FIRE RISK MANAGEMENT, INC

Memo Report

Subject: Independent Fire Protection Review for Cumberland County Civic Center Renovations

A review has been completed of the updated sets of fire protection construction documents (CD), which have been developed to support renovation efforts at the Cumberland County Civic Center in Portland, ME. The documents reviewed included both the fire protection demolition and design drawings (updated 4/12/13), along with the design specifications (updated 4/2/13) for the various fire protection and life safety related systems and the Building Code Report (dated 4/16/13).

SHEET No. **LSB.30**

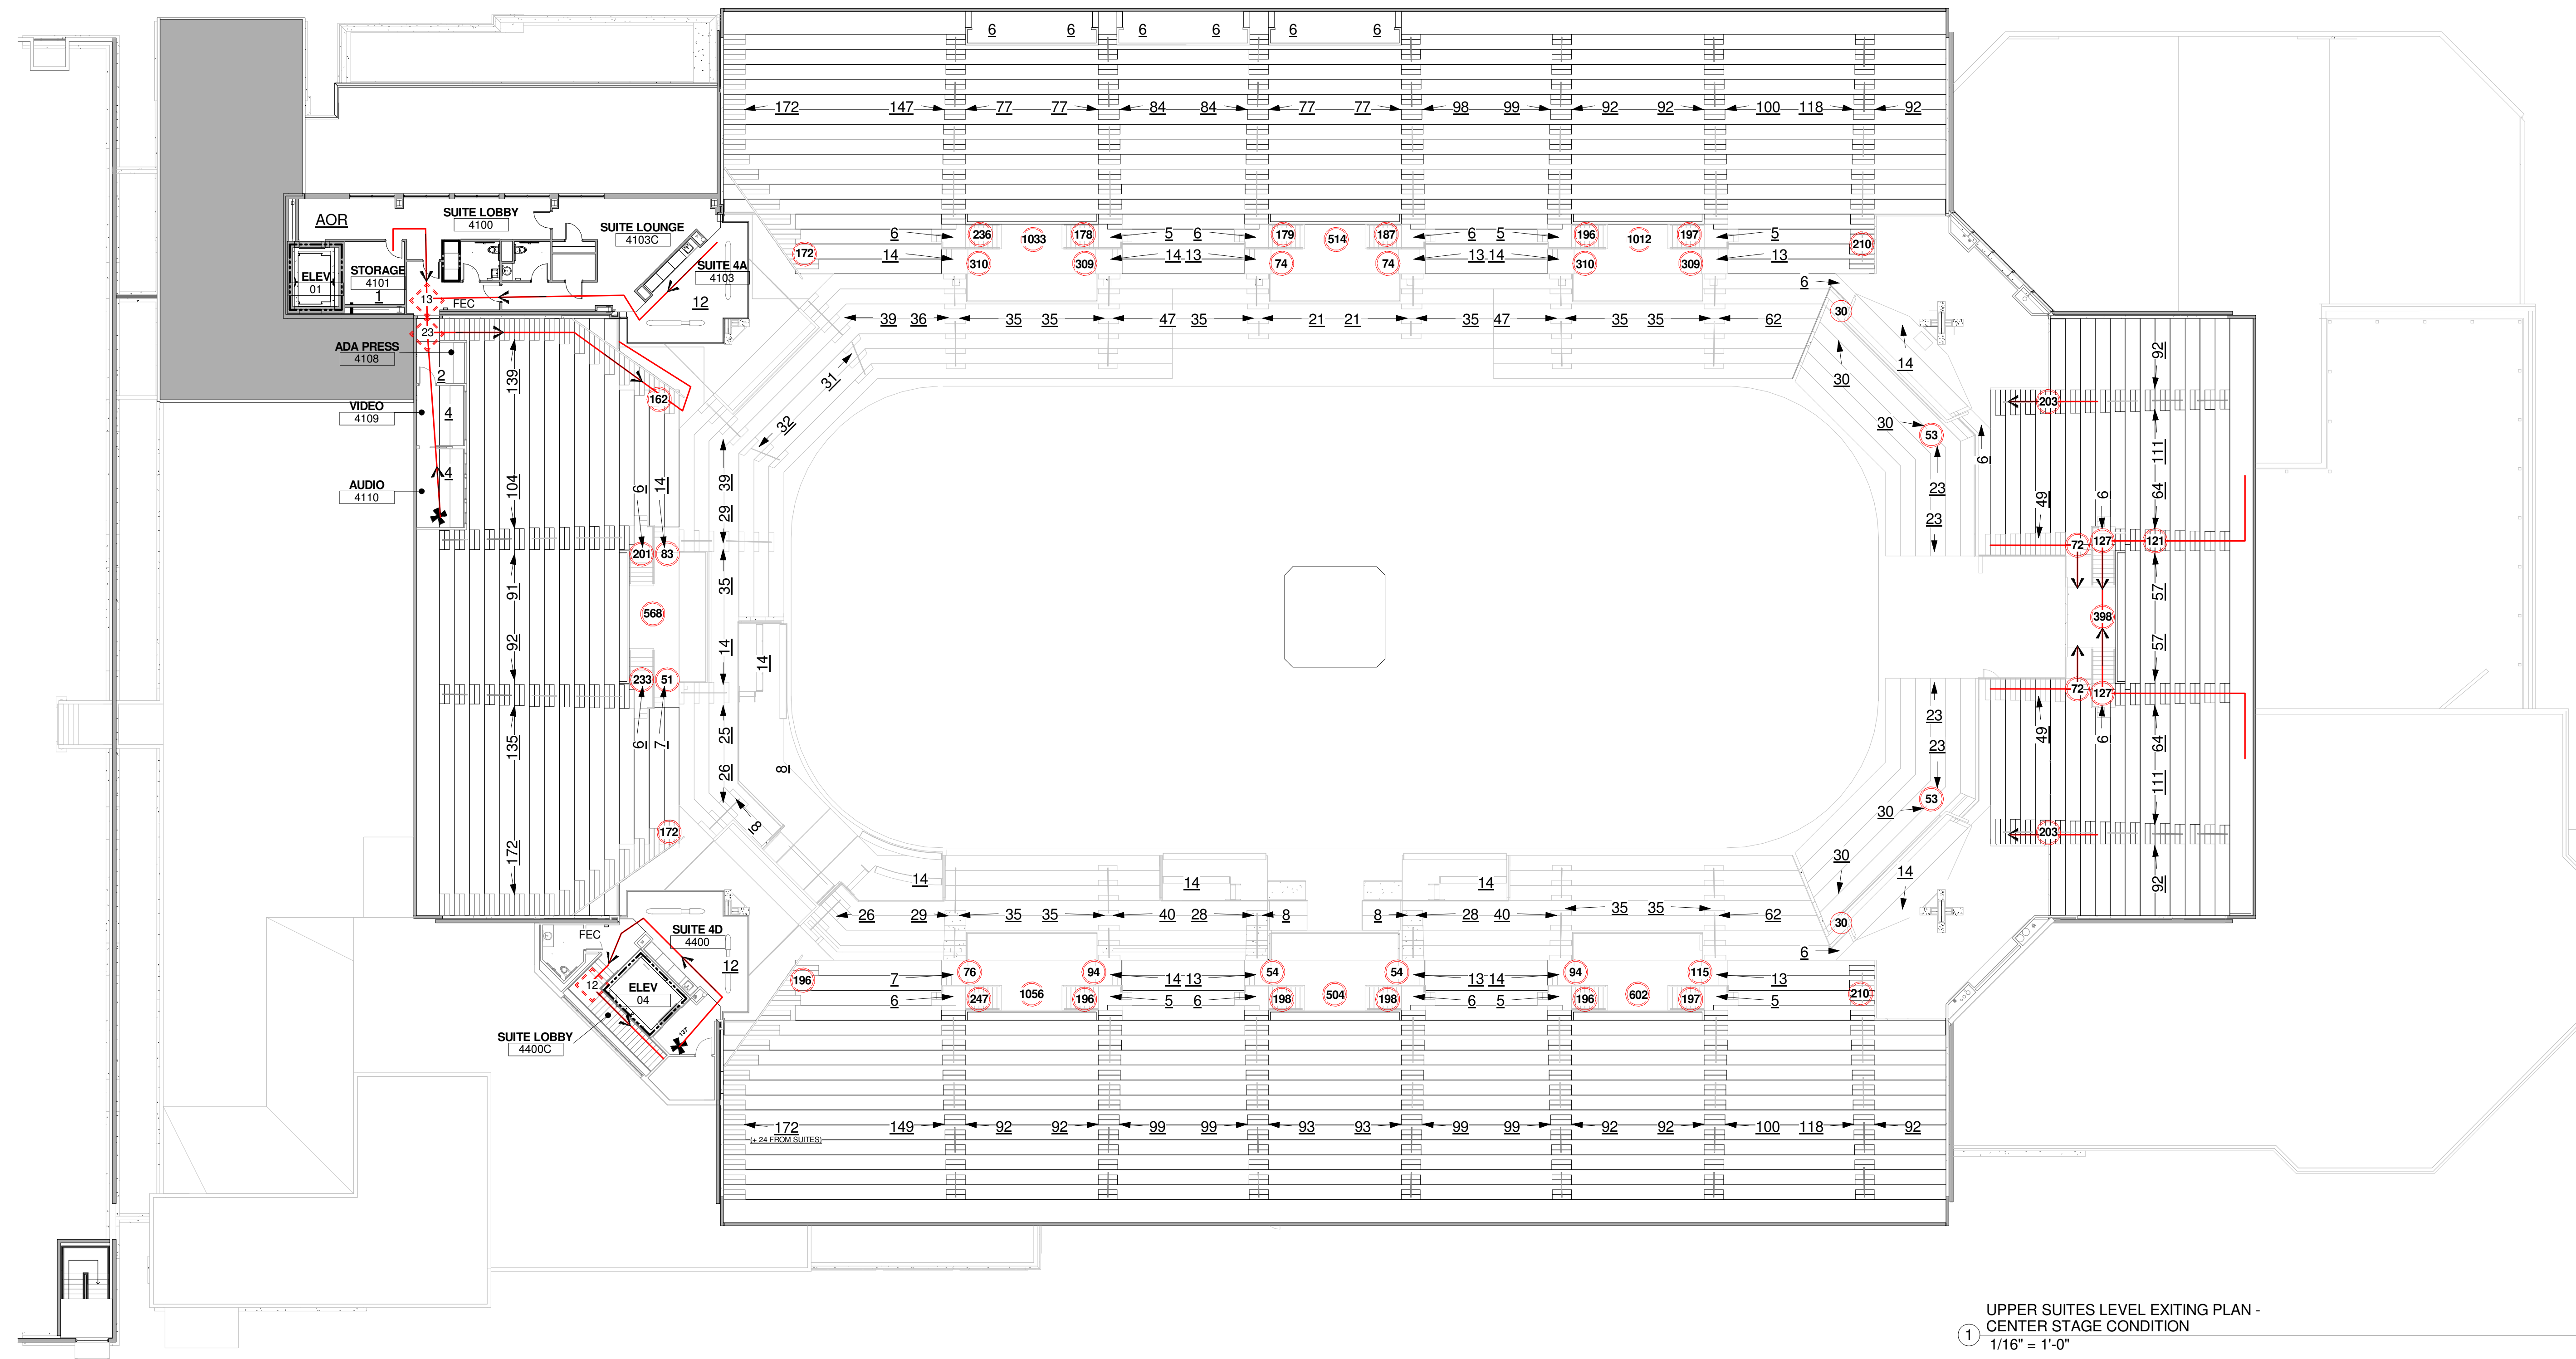
Some of the fire barrier requirements are still not properly depicted on the Life Safety (LS) Plans. For example, no fire rated barrier is shown for the Fire Pump Room; albeit other drawings properly indicate that the pump room will be isolated by walls having a 1-hour fire resistance rating. Is the elevator pit for elevator in the Mechanical Level open to the Elevator Machinery Room? If so, the machinery room needs to be isolated from the rest of the building with barriers having the same fire resistance rating as the elevator shaft (at least 1-hour, since this connects only three floors); otherwise, will simply need to ensure that any penetrations between these two areas are provided with proper penetration seal materials. Also, the store room adjacent to the elevator machinery room indicates the need for a 1-hour fire barrier. Is this meant to include the bounding walls of the store room or simply for the ceiling above? This should be better clarified, since the room itself would not require such a fire rating.

The occupant load calculations for the home team locker room and its associated spaces/areas, including office areas, do not appear to accurately reflect the load factors that should be applied within all the various spaces. Also, the stair located on the west end of the Event Level that leads up to the Concourse Level, does not appear to be provided with intermediate railings. These stairs appear to be much wider than the 5-foot (60 inch) maximum that would be allowed without the need to install additional handrails. [Note: An 88 inch maximum distance between handrails is allowed for "existing" buildings.] The current plan for the design of these stairs should be reviewed to determine if an additional handrail(s) is needed.

The path of egress from the Commissary area should be revised to properly reflect the actual path of travel to be used. Currently the path indicated depicts travel "through" a wall(s). Although the maximum travel distance will not be problematic, the path shown on the LS Plans should still reflect the code-required path of travel.

The location of the Fire Command Center should be identified on the LS Plans.
